October 16, 2012

Project Name: Modular Block Retaining Wall
Project ID: 2012-585
Address: 55 Sherman Street
CBL: 048-D-022001
Applicant: Michelle Dunham

On October 16, 2012, the Planning Authority approved with conditions a Level I: Site Alteration site plan for the construction of a modular block retaining wall. The decision is based upon the application, documents, and plans as prepared and submitted by St. Clair Associates Nancy St. Clair P.E, and dated as follows: Site/Grading Plan dated 6-18-12 revision D dated 9-24-12, Details dated 6-18-12 revision A dated 8-24 -12; and Proposed Segmental Retaining Wall Plan sheets W1 through W4, prepared by Steven R. Grant, P.E. dated 8-17-12 revised 10-8-12 and 8-20-12. The proposal was reviewed for conformance with the standards of Portland's site plan ordinance.

SITE/GRADING PLAN
OF:
GRASSHOPPER APARTMENTS LLC
55 SHERMAN STREET
PORTLAND, MAINE
FOR:
MICHELLE DUNHAM/GRASSHOPPER APARTMENTS LLC
55 SHERMAN STREET
PORTLAND, ME 04101

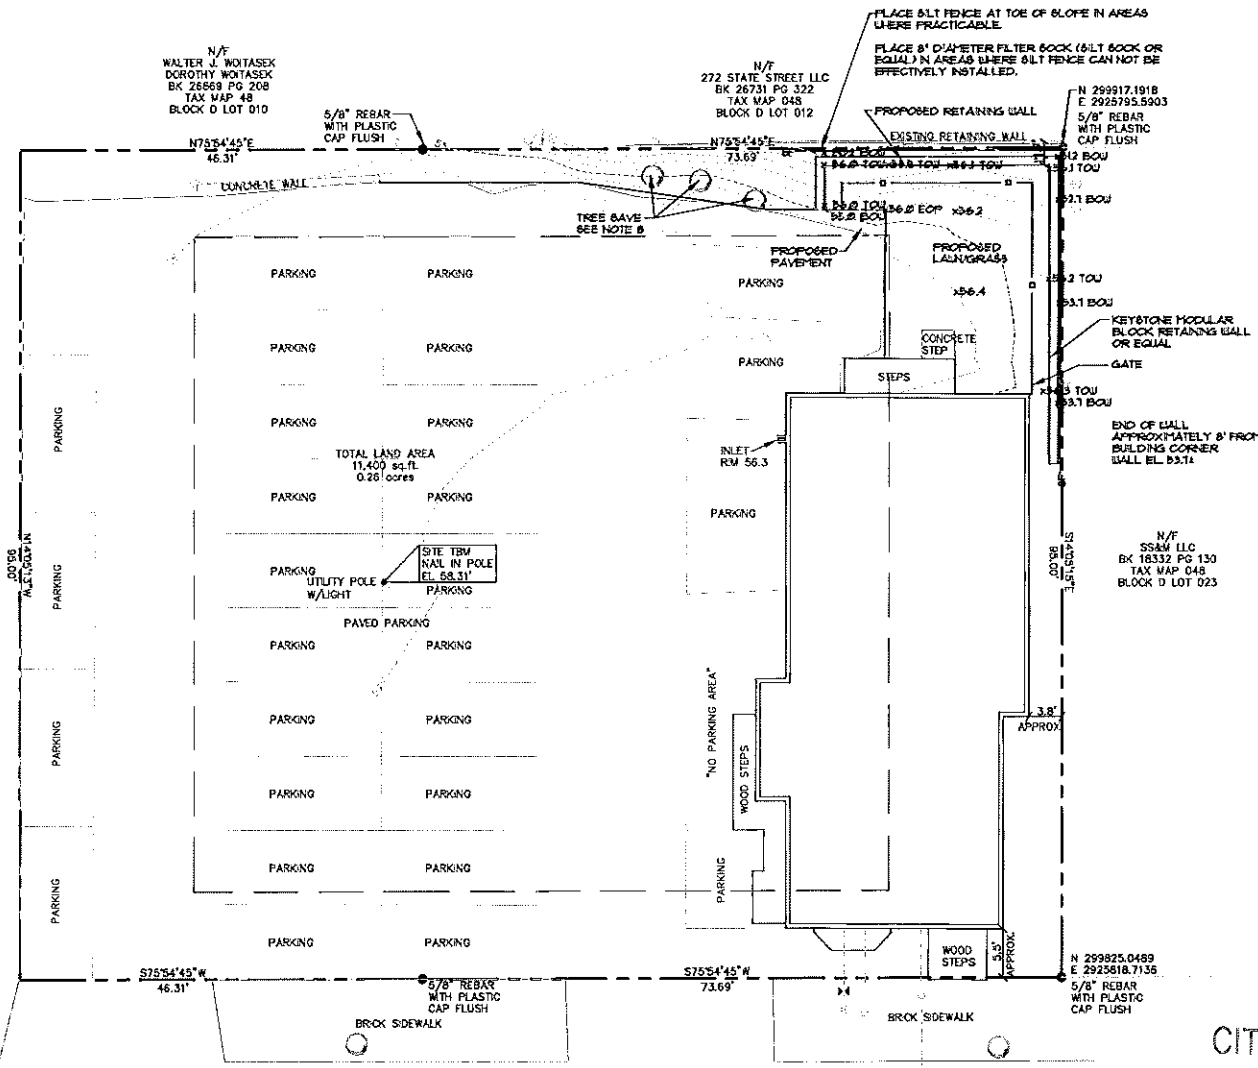
1. Flat faced block will be used in the construction of the retaining wall in order for it to blend more naturally with the surrounding properties that are located in the Historic District.
2. The applicant is required to obtain a building permit for the retaining wall from the Inspections Department.
